# CITY OF PORTLAND, MAINE

Project Name: 101 York Street Mixed Use Development  
Project ID: 2015-139  
Address: 85-101 York Street CBLs: 40-C-3, 4, 5, 9, 18, 22, 25, 33  
Applicant: 101 York Street, LLC  
Planner: Nell Donaldson

101 York Street Mixed Use Development  
85-101 York Street  
Level III Site Plan and Subdivision Review – Condition of Approval, Design Review  
2015-139  
101 York Street, LLC

Submitted to: Portland Planning Board Date: March 4, 2016 Public Hearing Date: March 8, 2016	Prepared by: Nell Donaldson, Planner CBLs: 40-C-3, 4, 5, 9, 18, 22, 25, 33 and 40-C-21 Project #: 2015-139
--	--

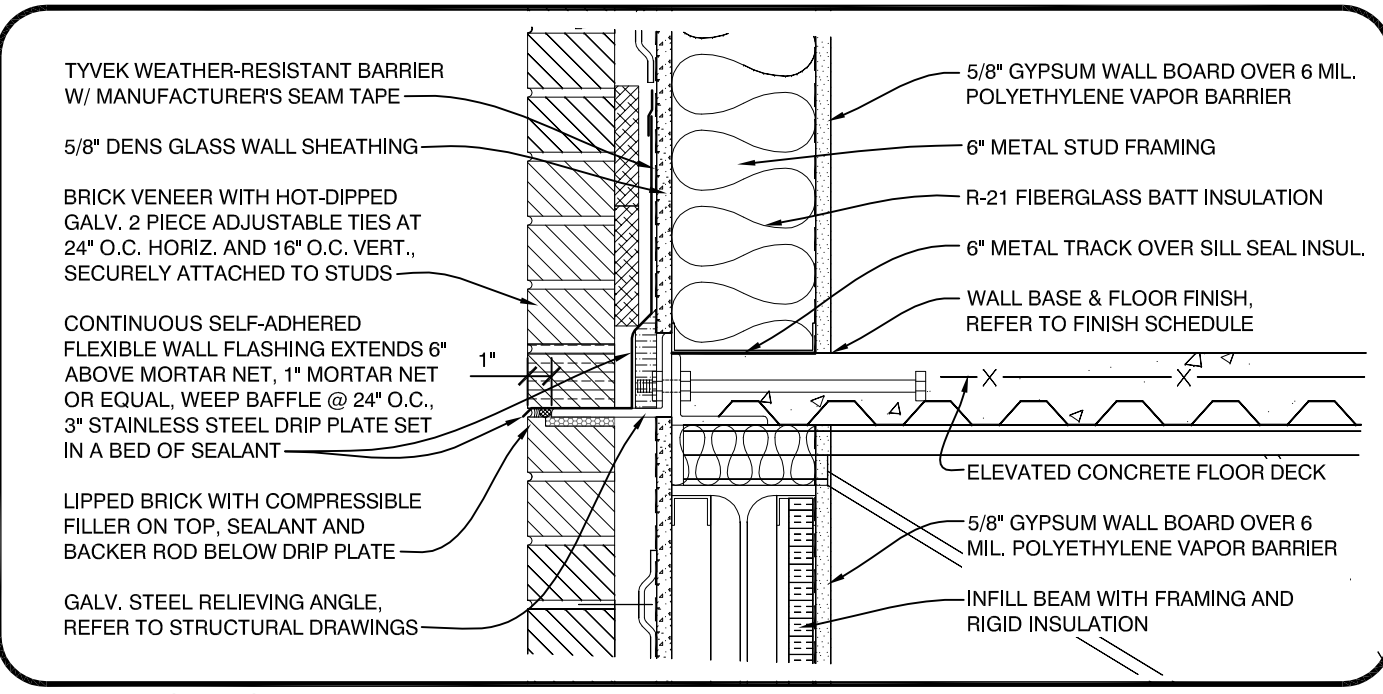
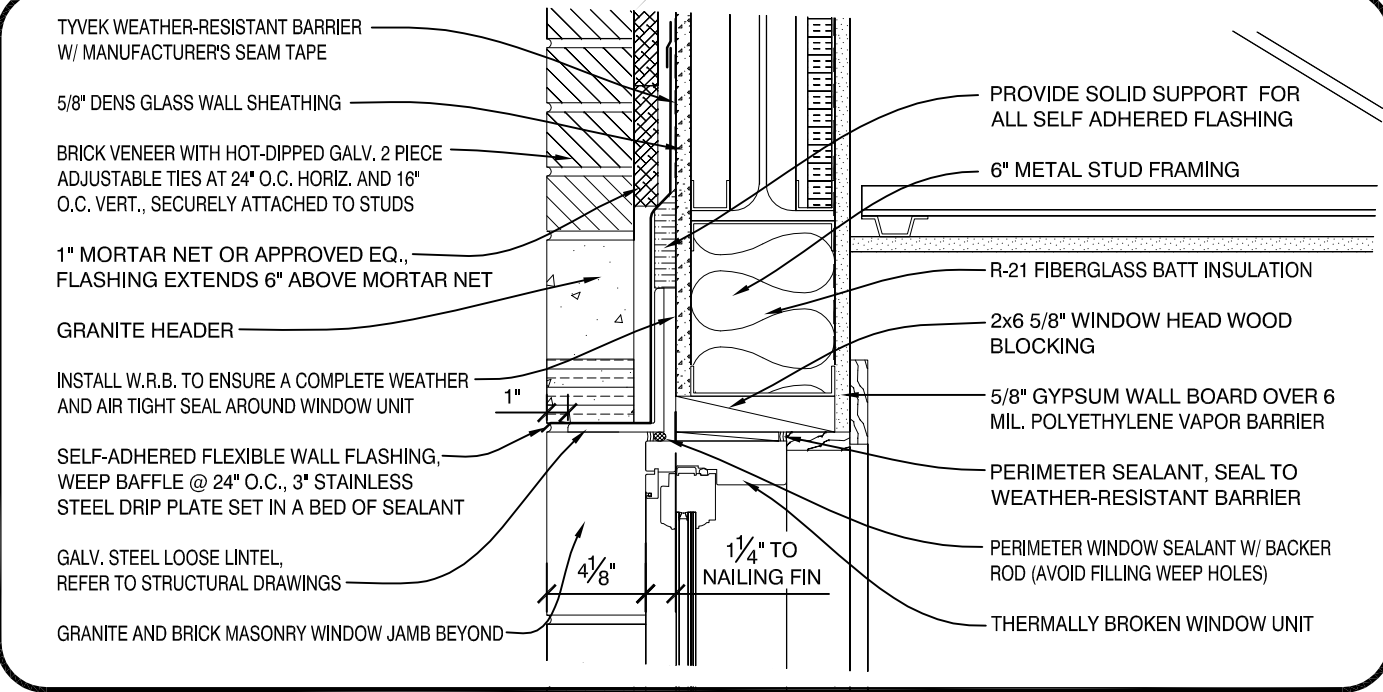
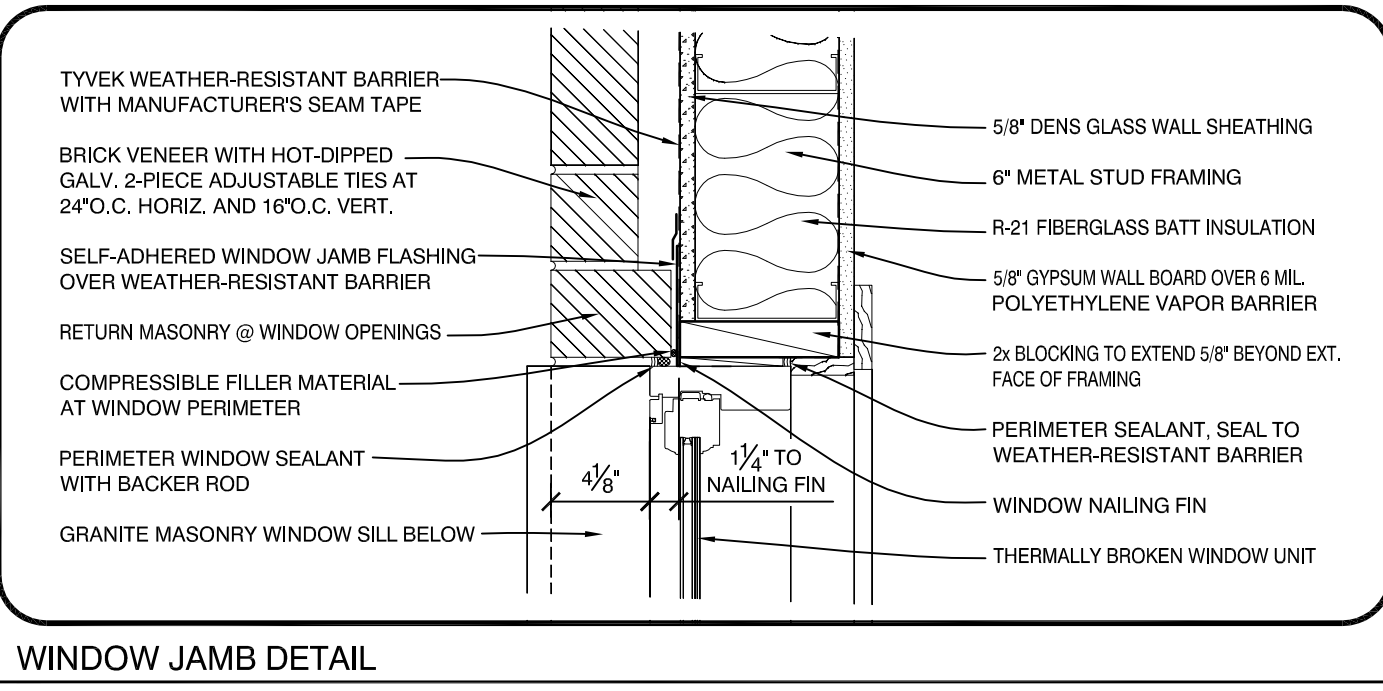
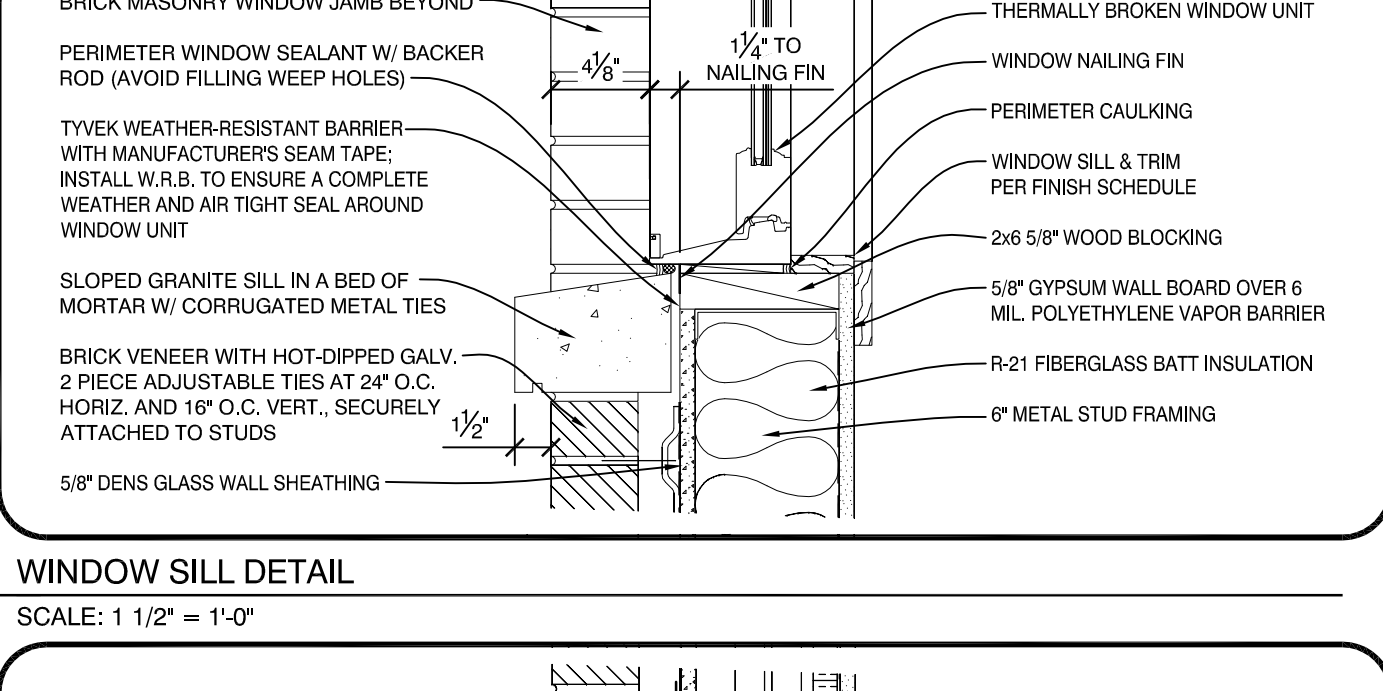
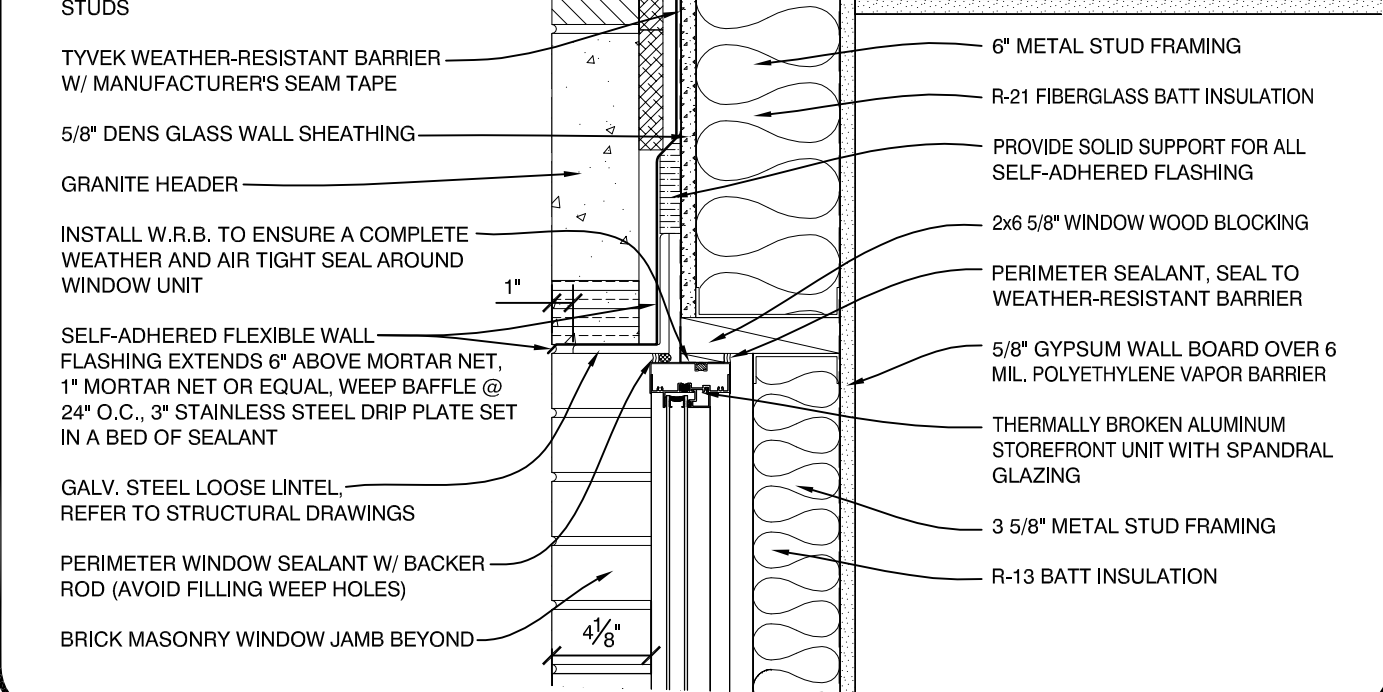
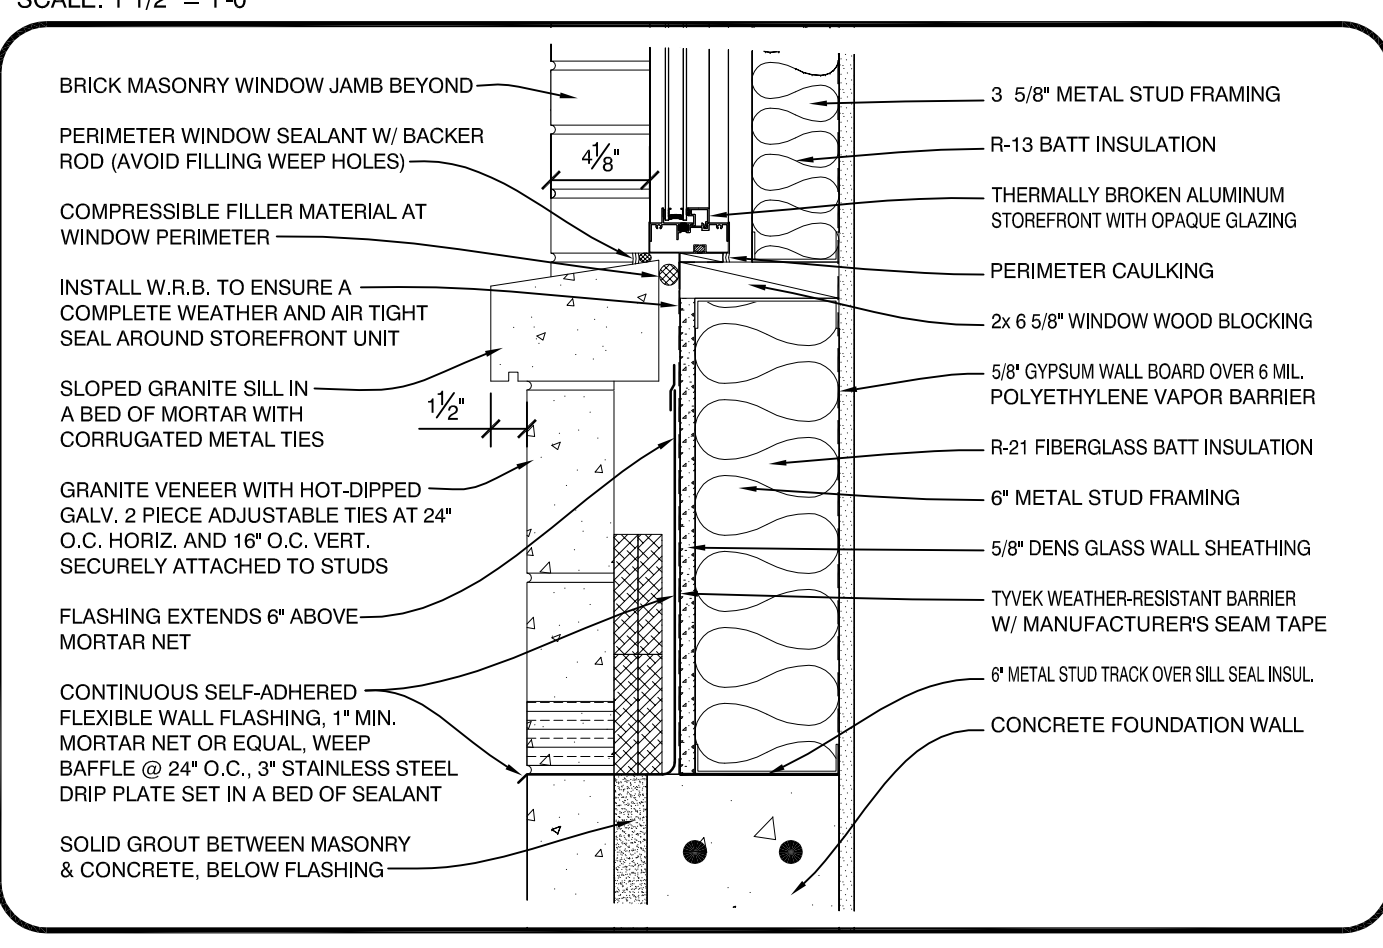
*Specific details on the design of elements meant to provide articulation, including wall sections and details of storefronts, cornices, and entrances and window and door specifications, have not been provided.*

- *Cornice:* Similarly, the applicant has changed the cornice color to match the storefront and reduce contrast with the buff brick veneer of the building's middle. In the final drawings, the applicant has also increased the height of the cornice piece and frieze trim to bring it more into proportion with the building's middle section.

- *Brick Courses:* The final drawings include an inset rowlock brick course and three accent bands of inset brickwork at 3/4" depth just below the building cornice. The applicant also proposes a soldier course at the sill level of the fifth story windows, with the intent of minimizing the proportion of the building's middle section.

- 1) **The high contrast of material colors** – The material finish of the cornice and storefront was revised to be lighter in tone and therefore, less contrasting.
- 2) **Durability and detail of materials at ground floor** – The applicant proposes a fiber cement panels and trim at the ground floor storefront. Wall sections

*show the level of reveal and shadow line created which ranges from 1" to 2" at upper floor accent bands to 6" to 10" at the base and sills.*

- 3) **Proportion of corner façade composition at the top of the building** – *The revisions to address this concern include a more substantial cornice profile at the corner, horizontal bands of brick above the windows, and a soldier course at the top floor windows.*
- 4) **Overall, not enough emphasis on the corner of the building as a gateway** – *The revisions mentioned above are intended to add more emphasis and visual interest at the corner of the building.*
- 5) **Planter and seating walls on High Street and to meet the additional setback -**
  - a. *The planter wall was added back to the High Street façade as requested*
  - b. *The design of the additional setback on York Street removes the physical barrier and adds amenities such as the street tree, raised planter, and seating.*
